From: Matthew Woodward
Sent: 07 February 2017 11:37
To: 'Nick Willock'
Subject: FW: Planning Application - 2017/90207

From: Matthew Woodward
Sent: 02 February 2017 09:25
To: 'nick@roberthalstead.co.uk'
Subject: Planning Application - 2017/90207

Outline application for erection of B1 light industry

Thongsbridge Mills, Miry Lane, Thongsbridge, Holmfirth, HD9 7RW

PROPOSED ACCESS FROM BOTH DIRECTIONS
SCALE: 1:250

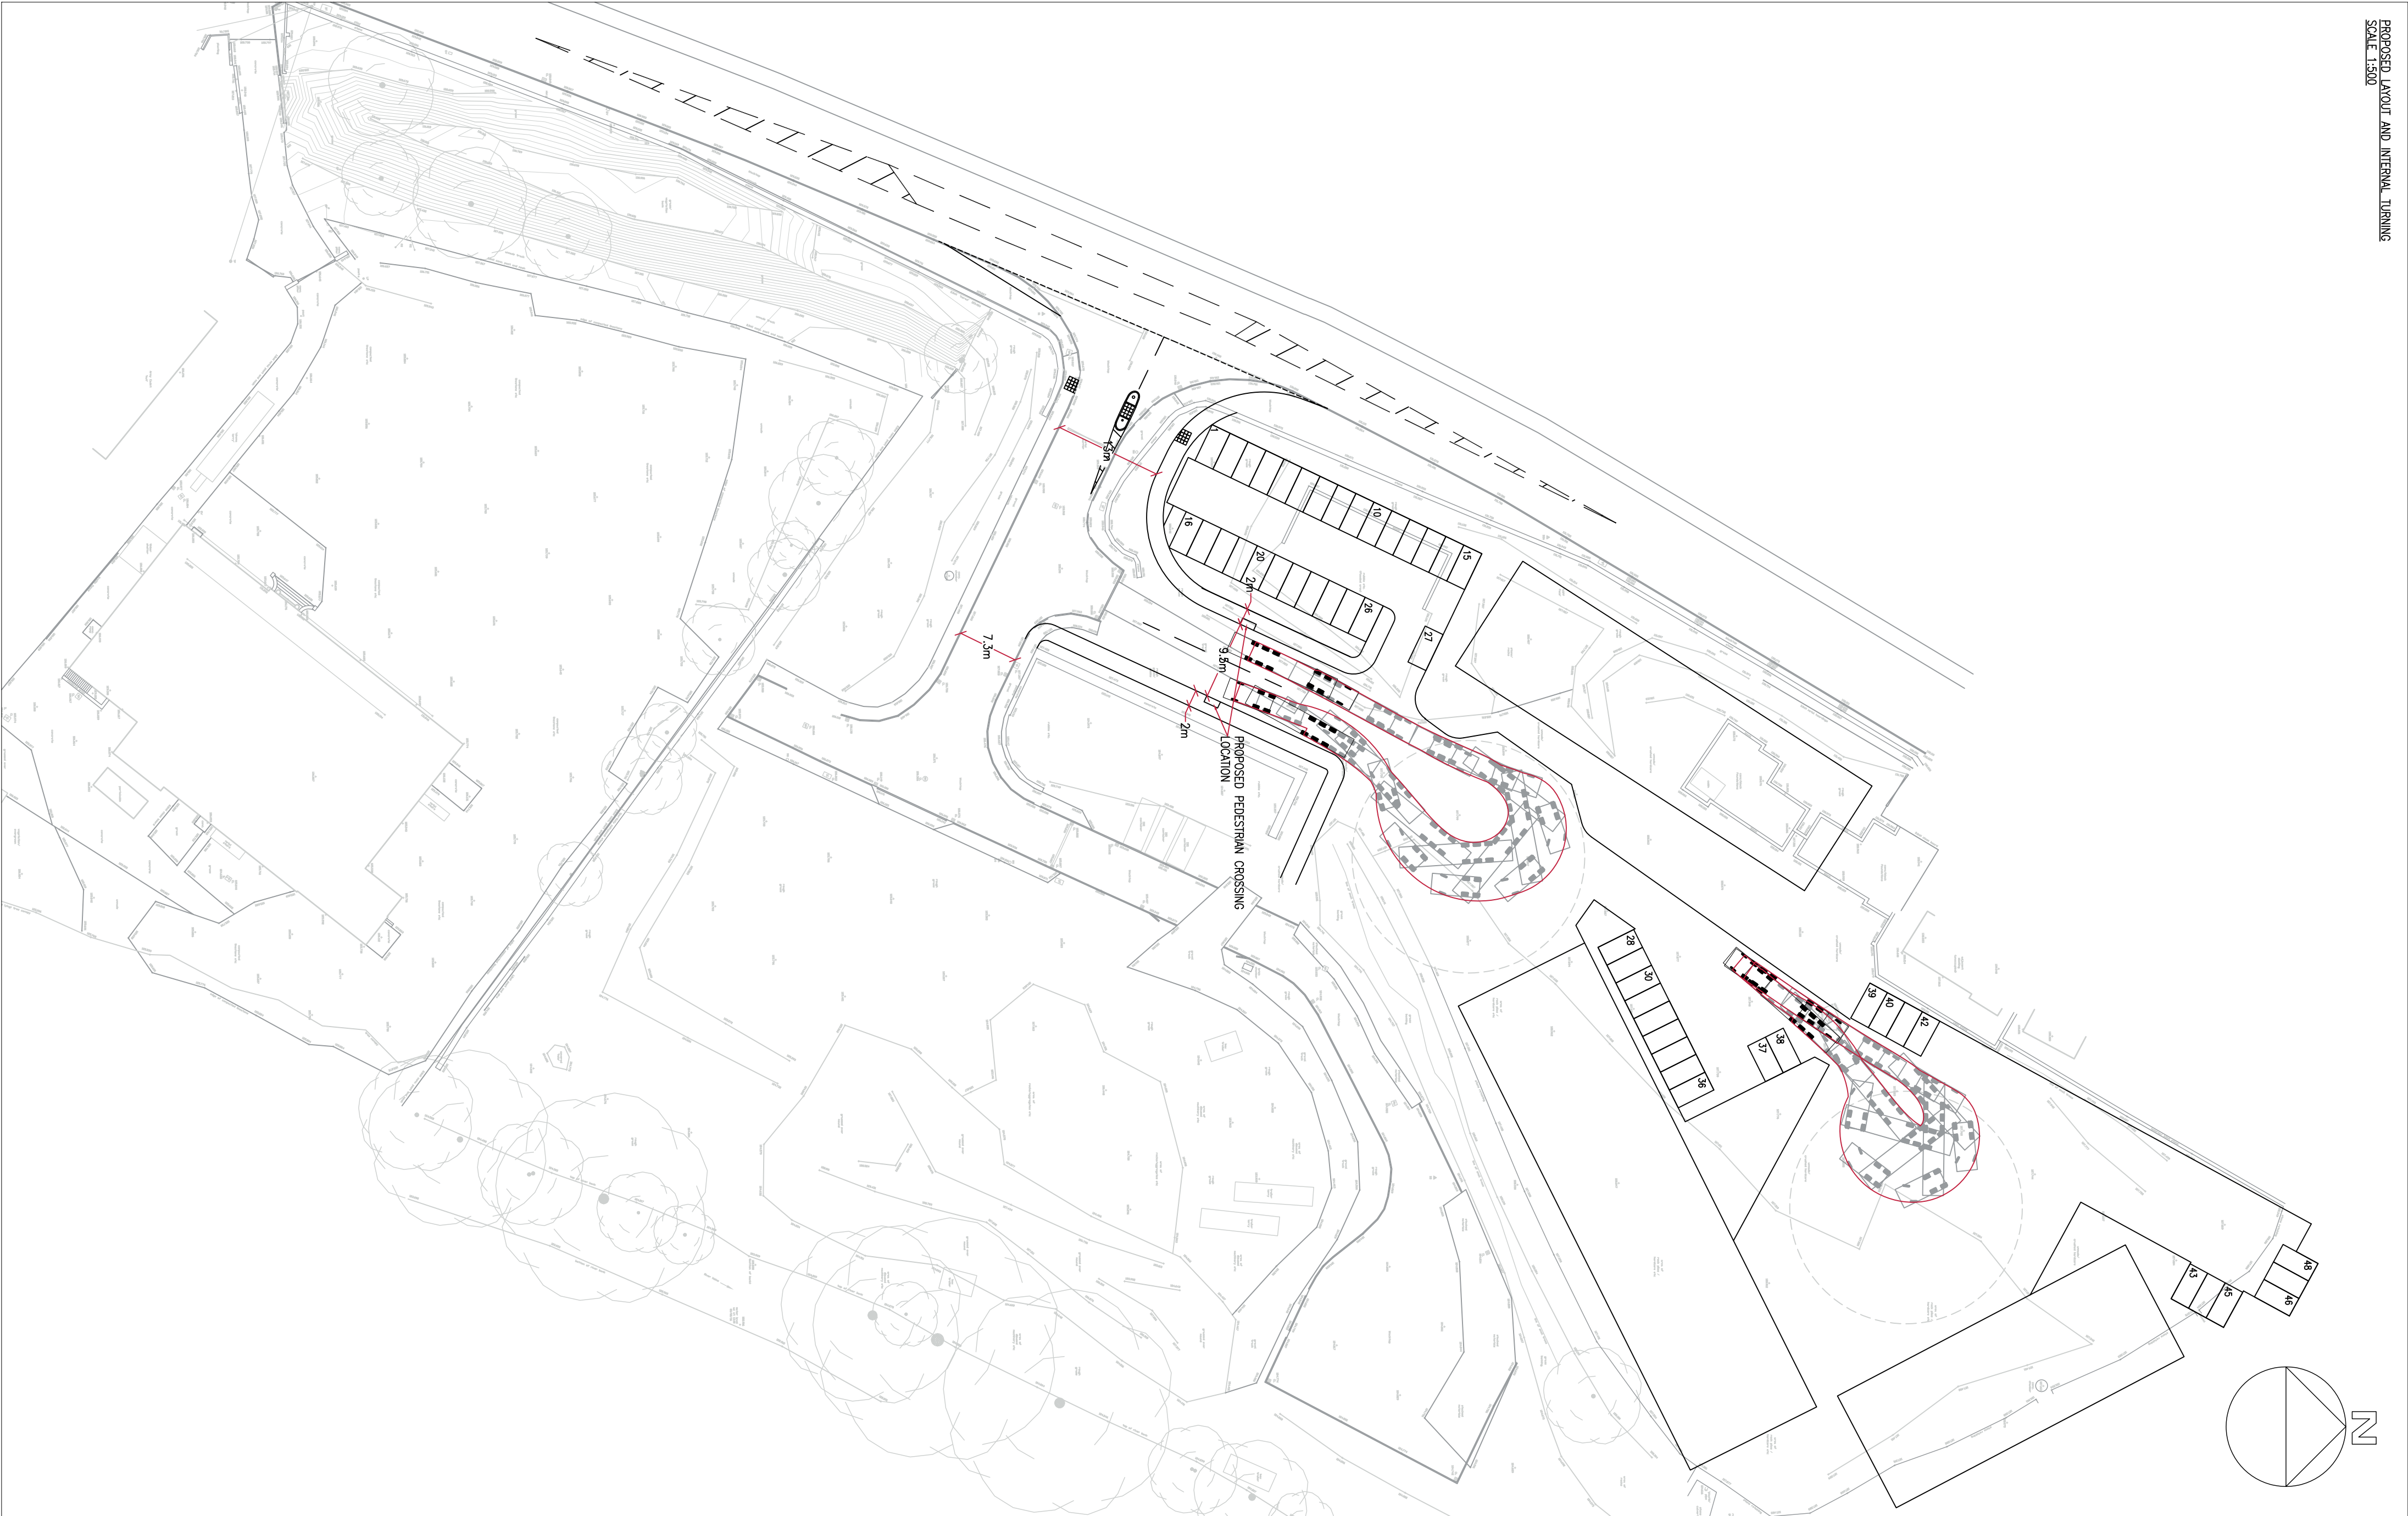
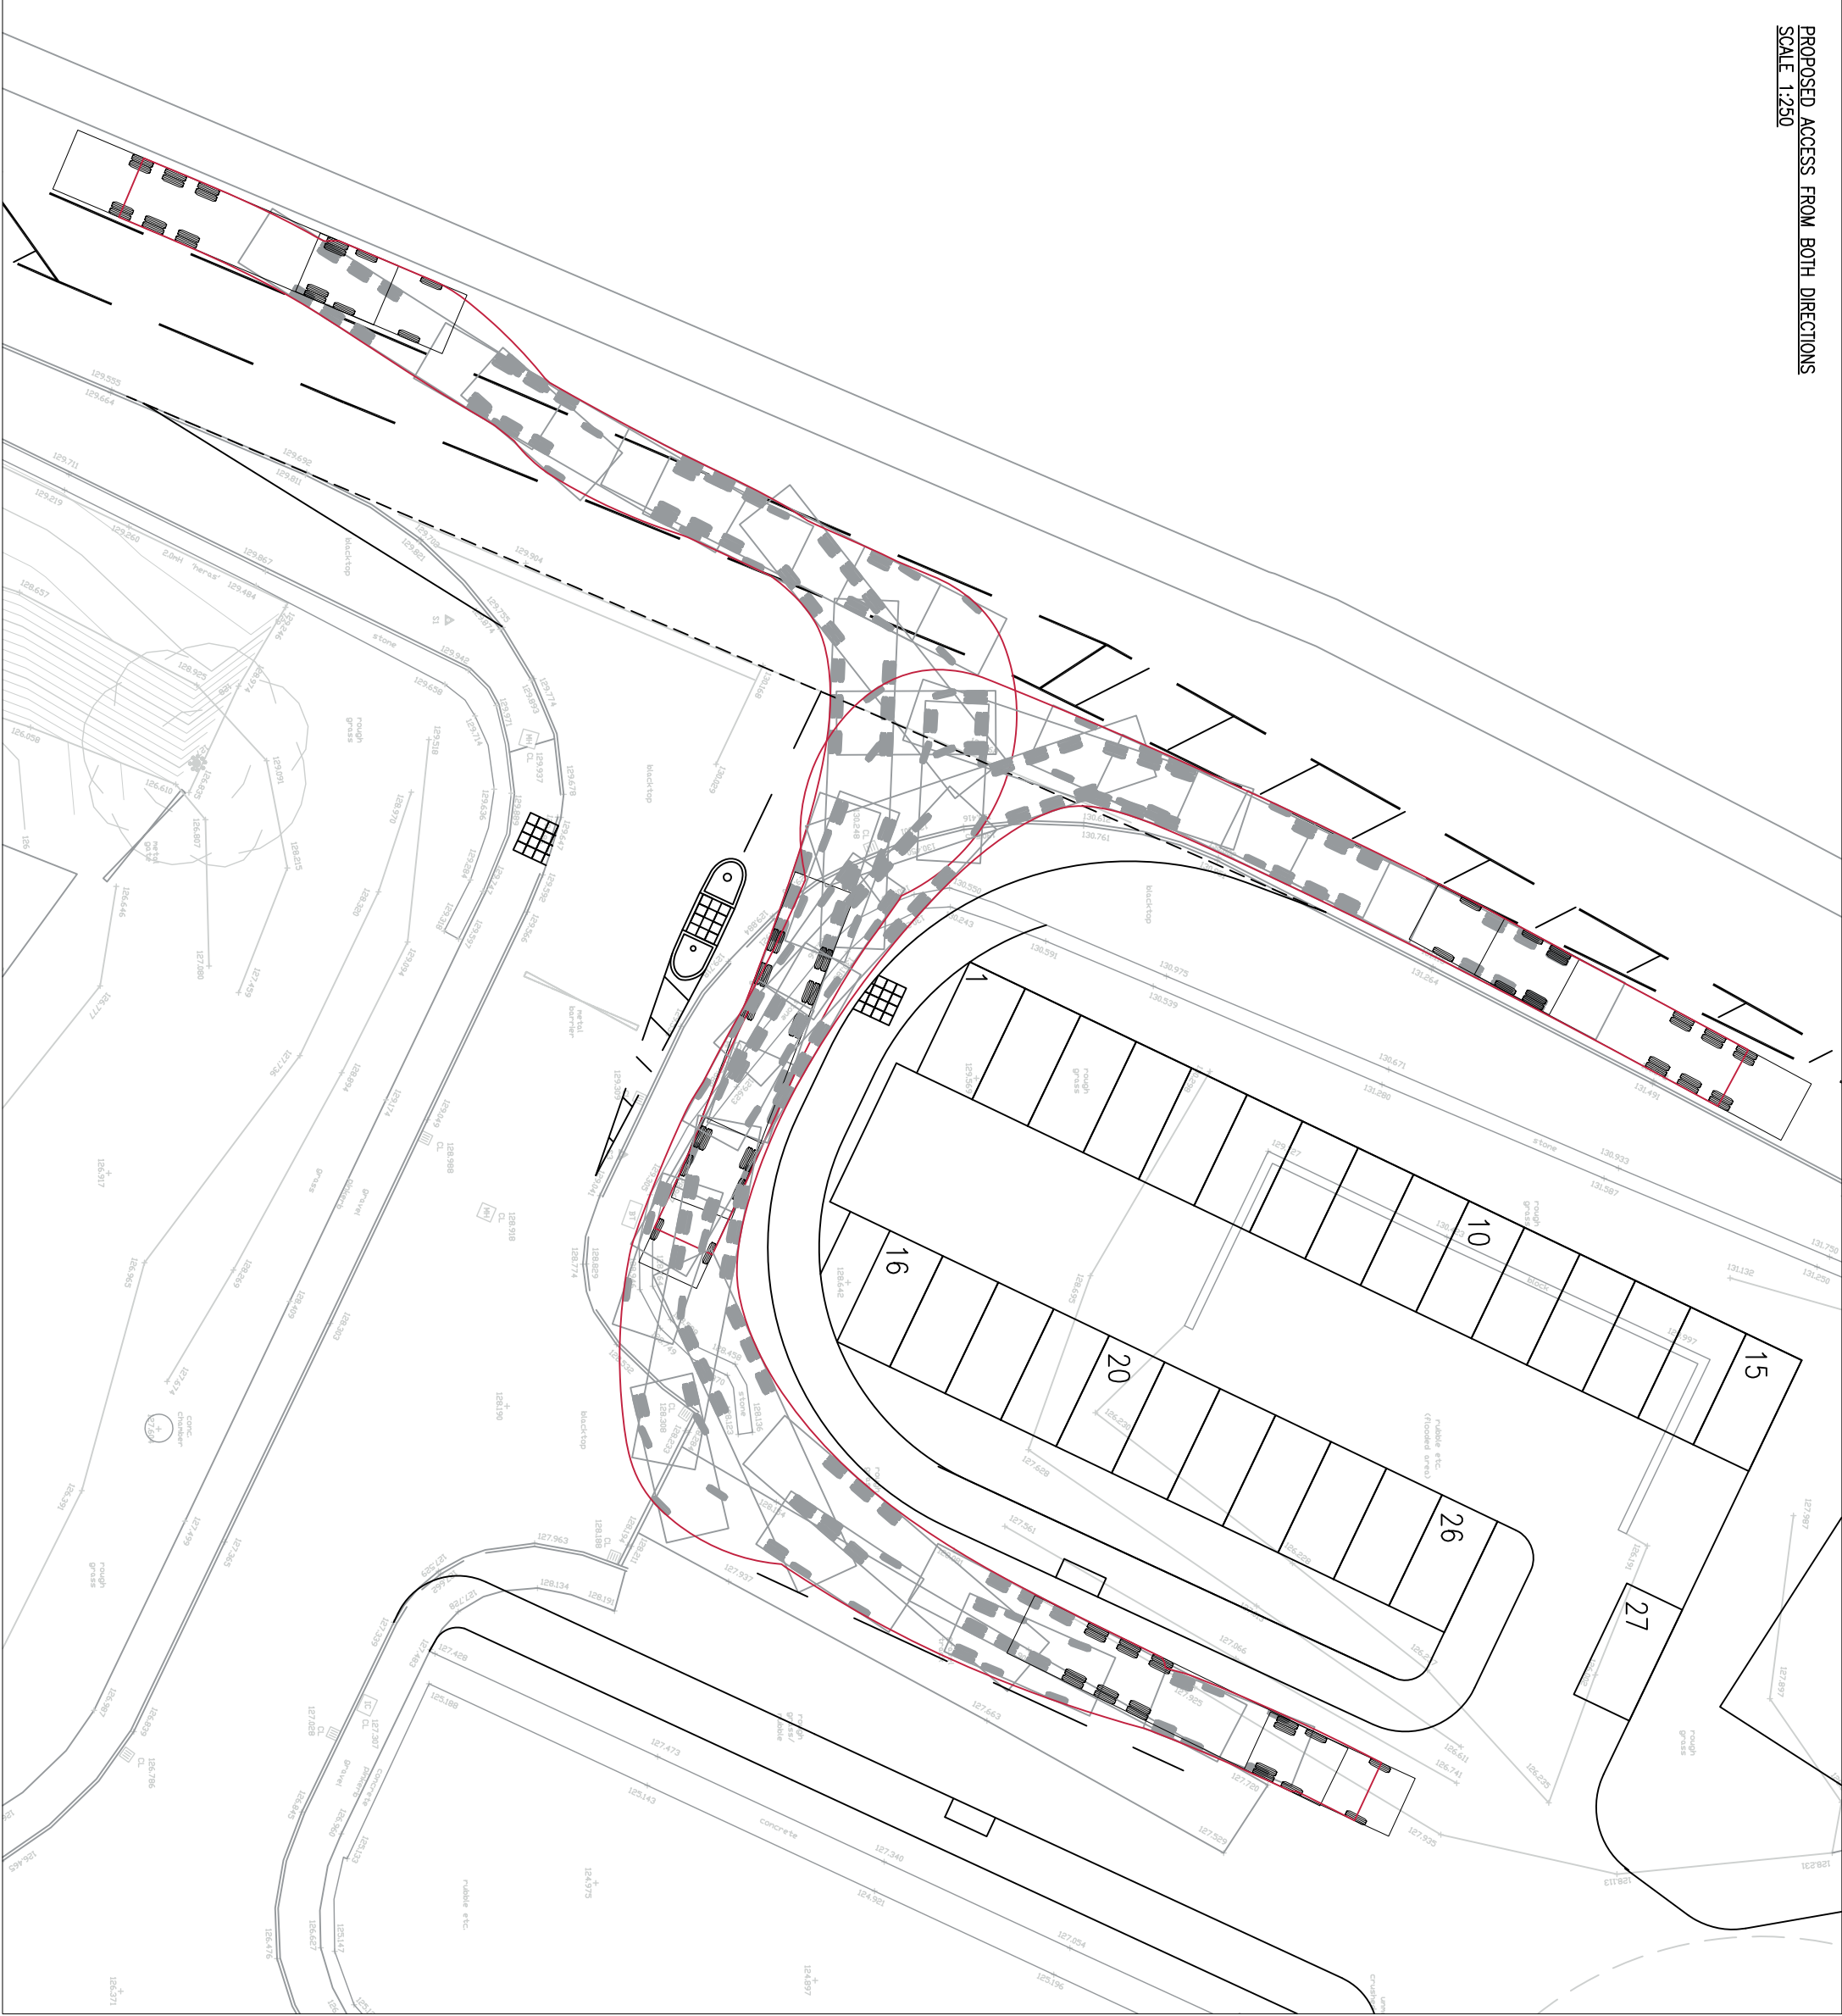
- 1) I cannot locate any access details other than an indicative access location, even though you are applying for full access details. Full plans showing details of the proposed access will be required even if the access is to remain unchanged.
- 2) I would expect the submission to include an indicative layout in order that the Council can understand how a building on the scale you propose will 'fit' in with its surroundings.
- 3) Scale parameters. No details submitted. I require an indication of the upper and lower limits for height, width and length of the building within the site boundary.
